4th January 2021

Application No: FP/231/20/PL
Site Address: Abergail Clyde Road Felpham PO22 7AH
Description of works: New building with first floor 1 No. 1- bed apartment above (3 x No.) garages & cycle store with parking. This site is in CIL Zone 4 (Zero Rated) as flat.

PROPOSED FIRST FLOOR PLAN

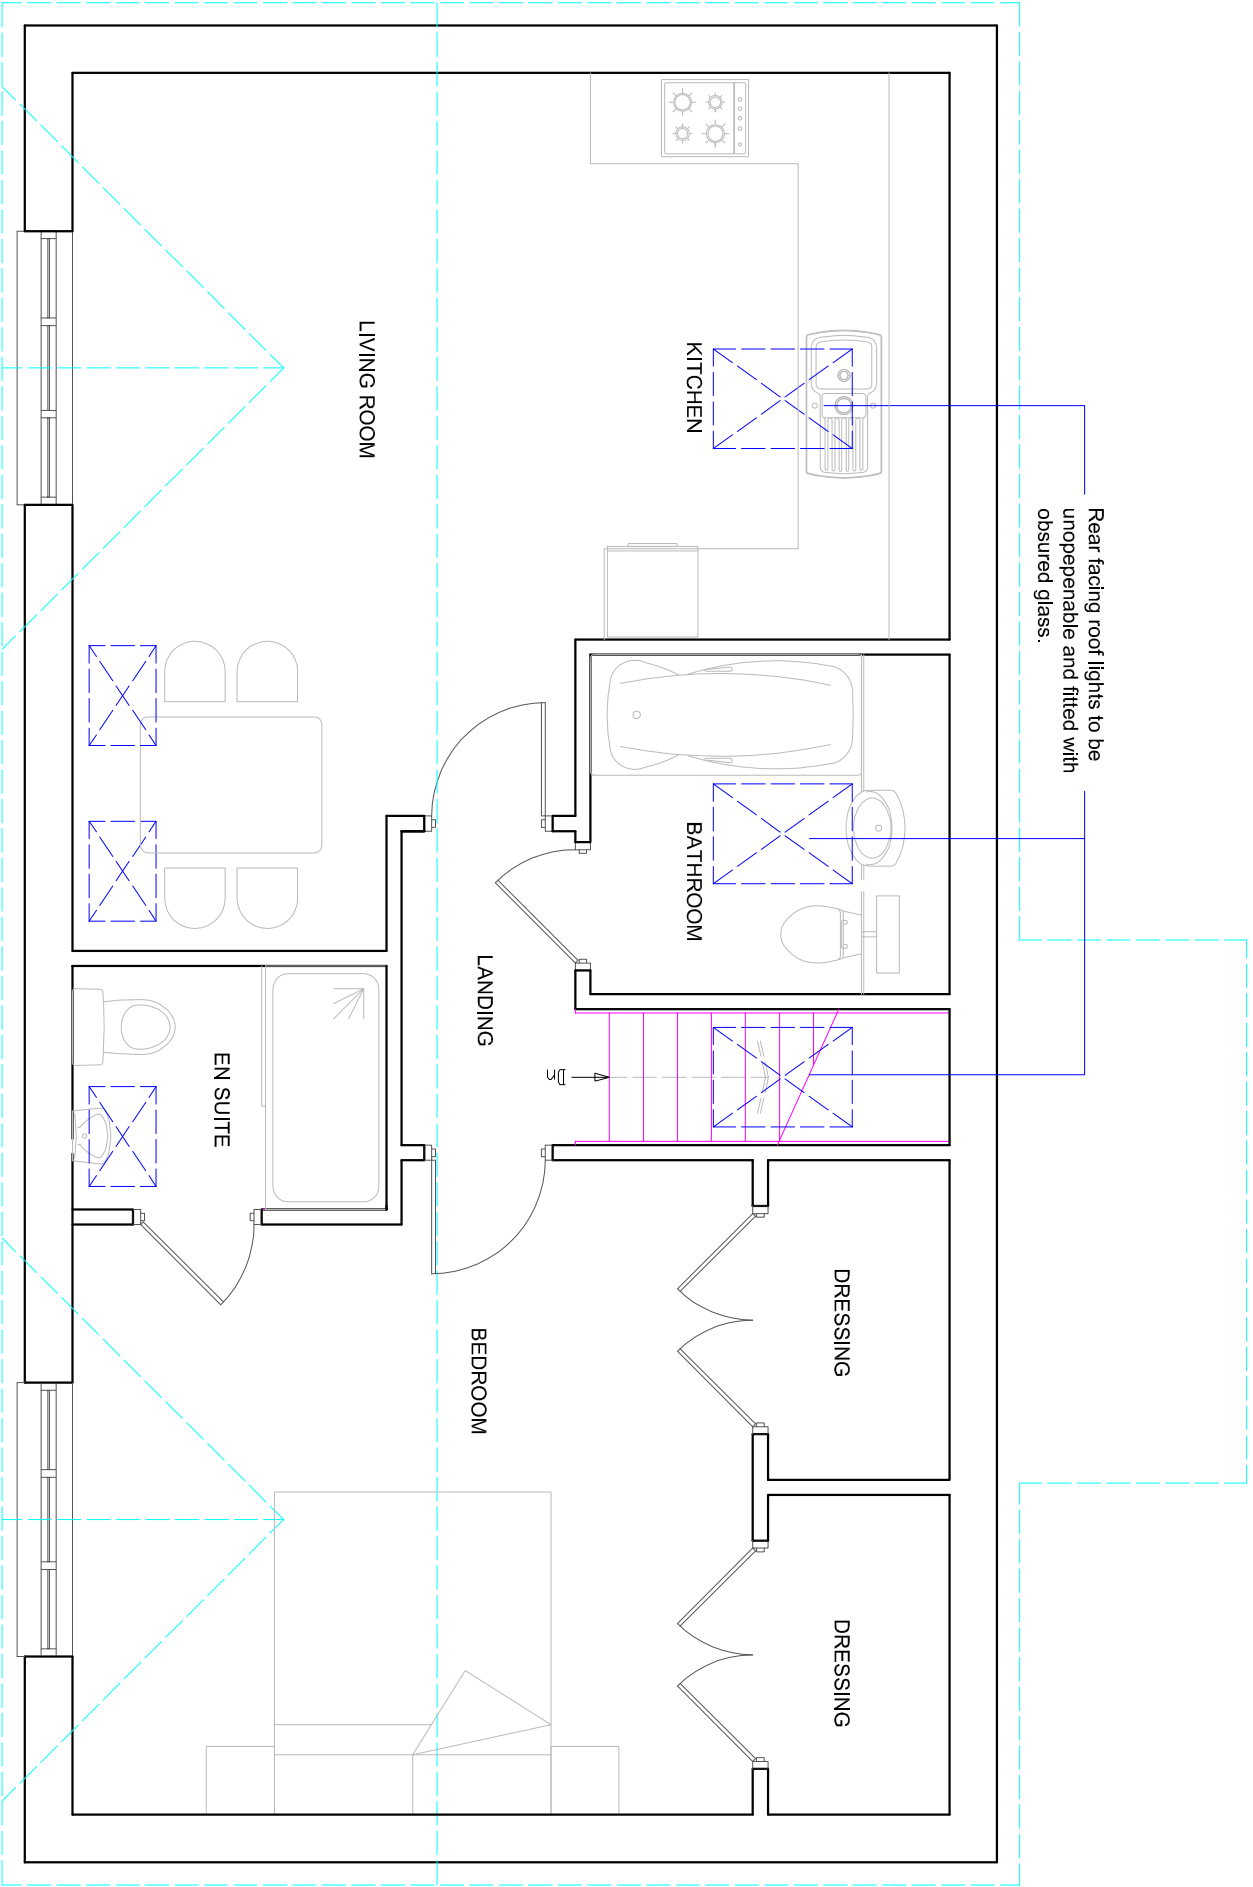
Objection - FPC would like to amend their wording to: Object - Build is within 1 metre separation at 1st floor level of a neighbouring property, therefore is non-compliant with ADC's Policy Guidelines DM4.
